LPA Ref: 3/2019/0953

SUBMISSION OF A NON-MATERIAL AMENDMENT APPLICATION (SECTION 96A) TO PLANNING PERMISSION 3/2019/0953 – APPROVED RESIDENTIAL DEVELOPMENT AT STANDEN PHASE 2, 3 AND 4, LAND AT HIGHER STANDEN FARM AND PART LITTLEMOOR FARM CLITHEROE

"Non-material amendment to reserved matters application 3/2019/0953, to amend an approved brick specification and update the layout of the bin and cycle storage, attached to Condition 1 (List of Approved Plans)"

TWHSF/WMP/02

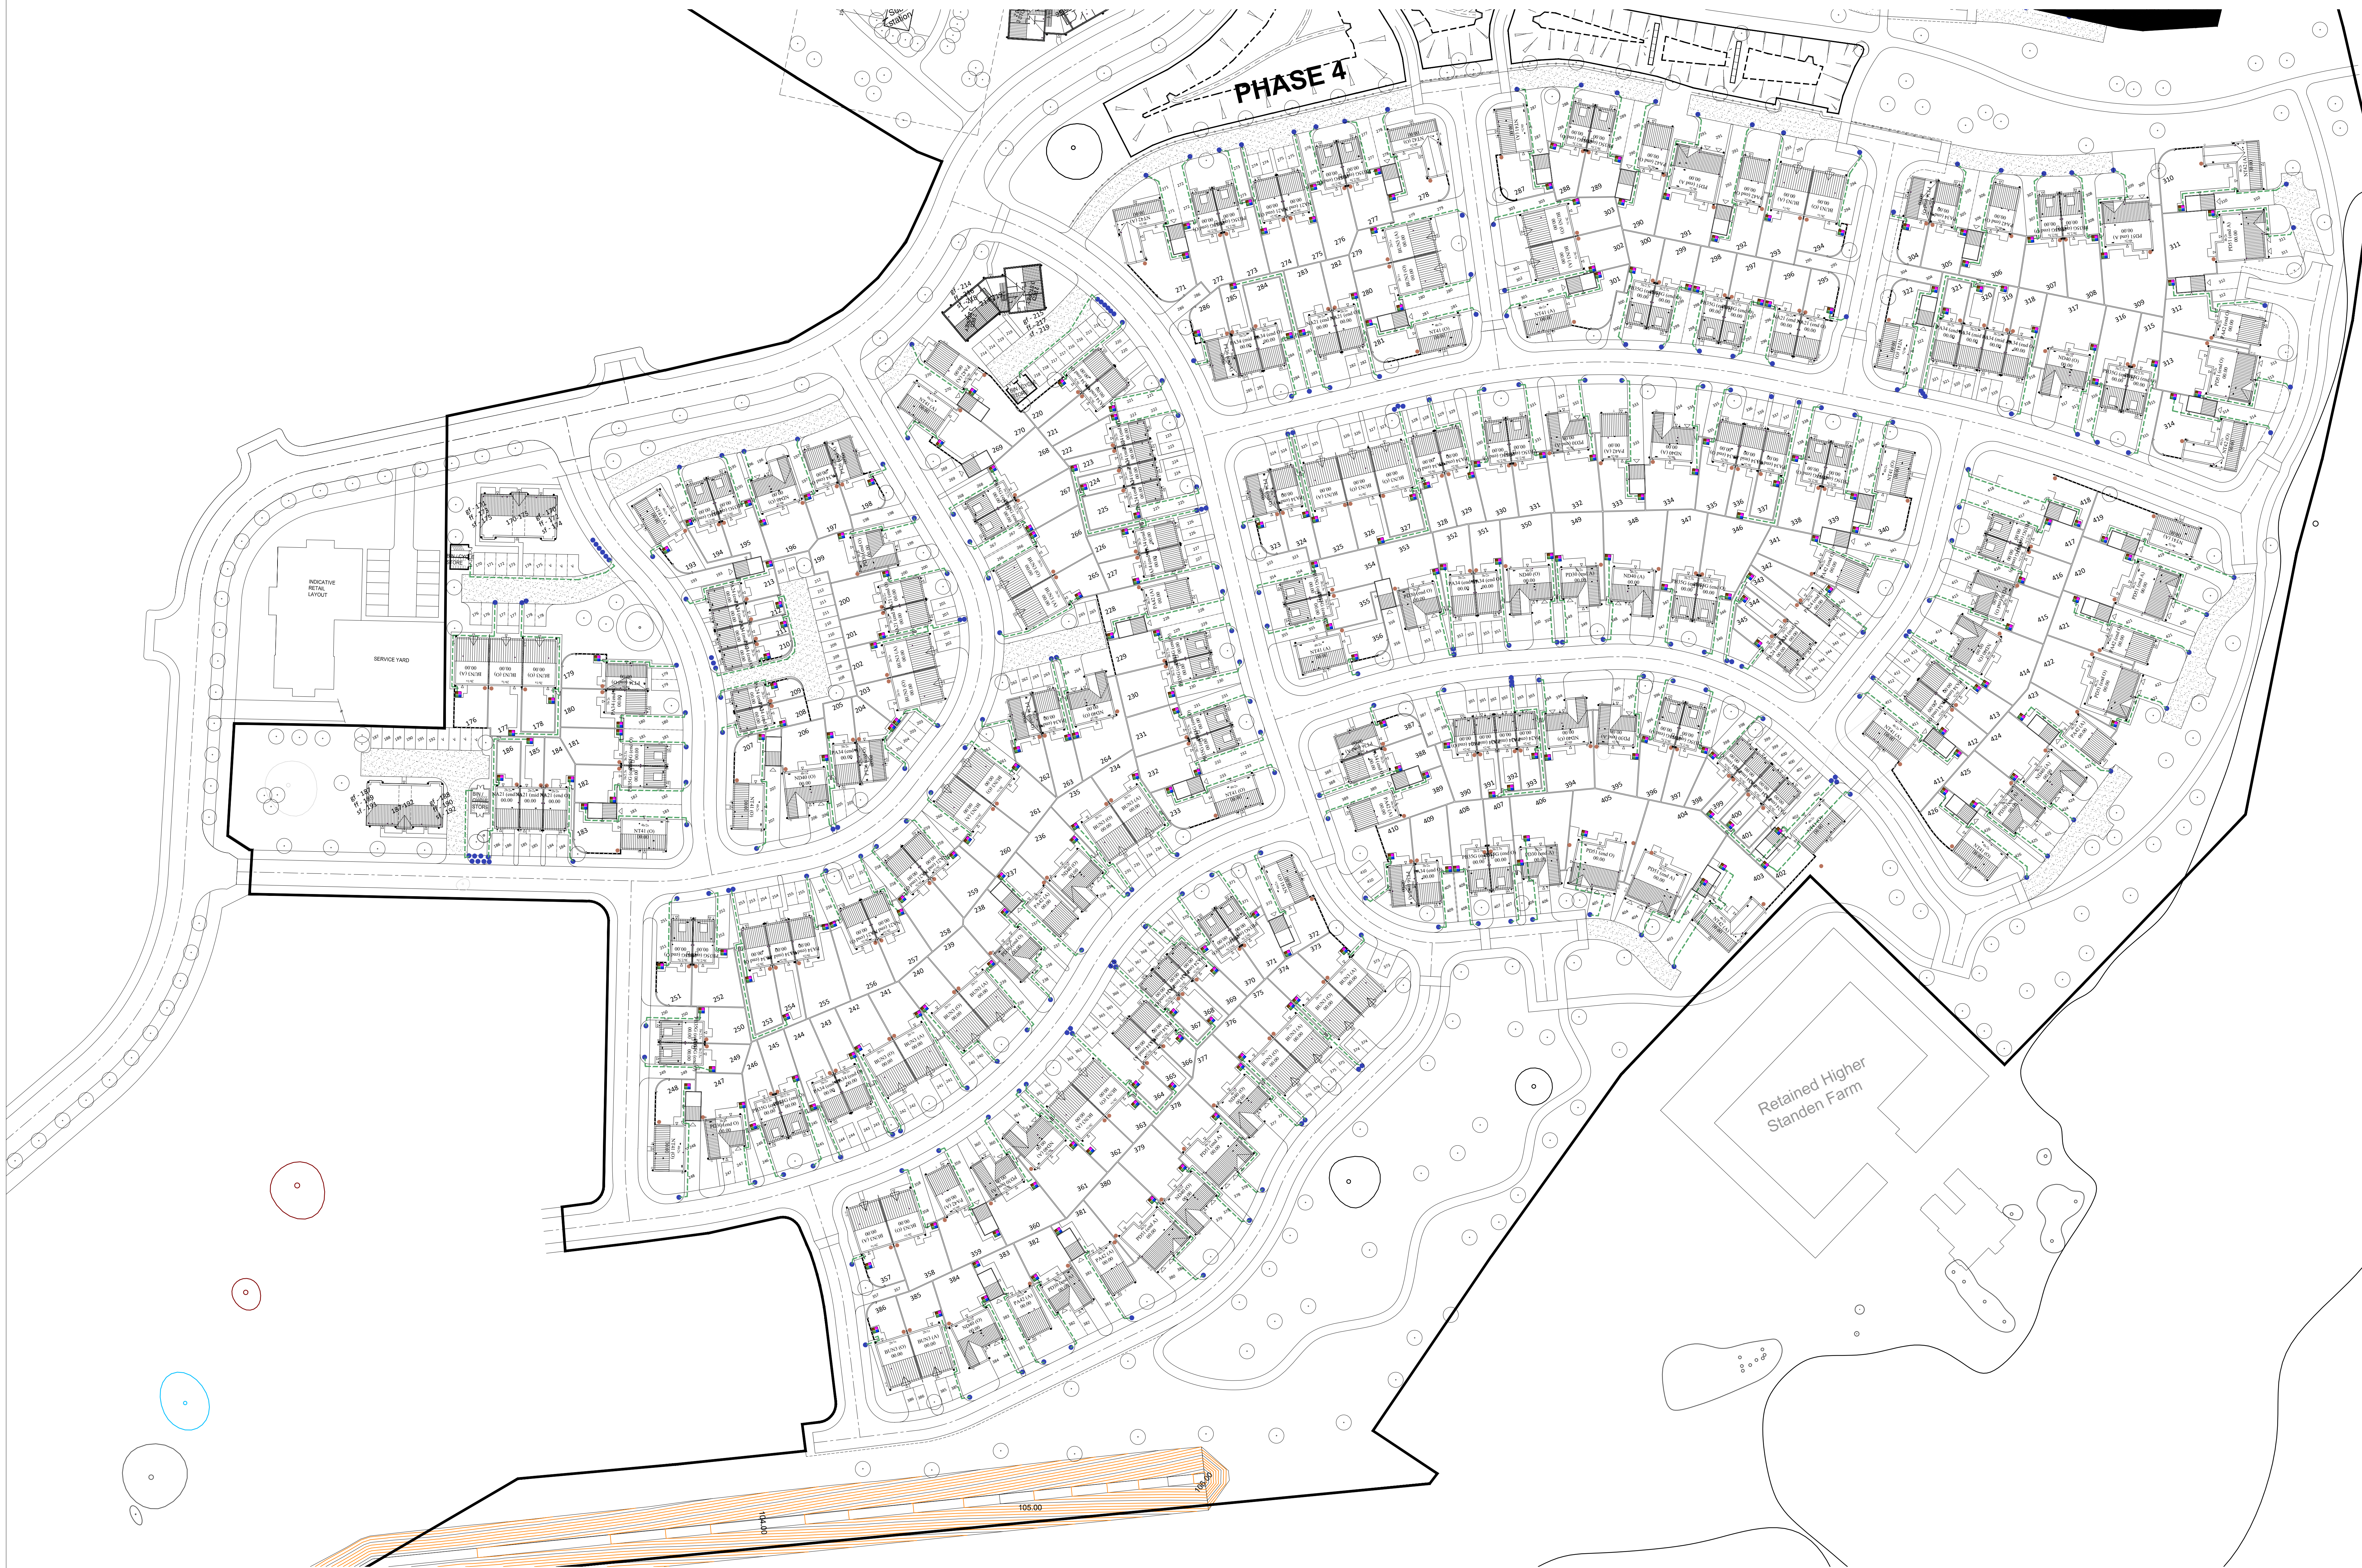
The proposed bin and cycle storage shown on plan reference TW/HSF/HT/65 is no longer in accordance with waste requirements set out by the Council. The Applicant is therefore proposing amendments to the size, location and layout of the approved bin and cycle storage to accommodate the required number of bins (12 no. of 140 litre bins per apartment block, in the form of 6 no. of general waste bins and 6 no. of recycling bins).
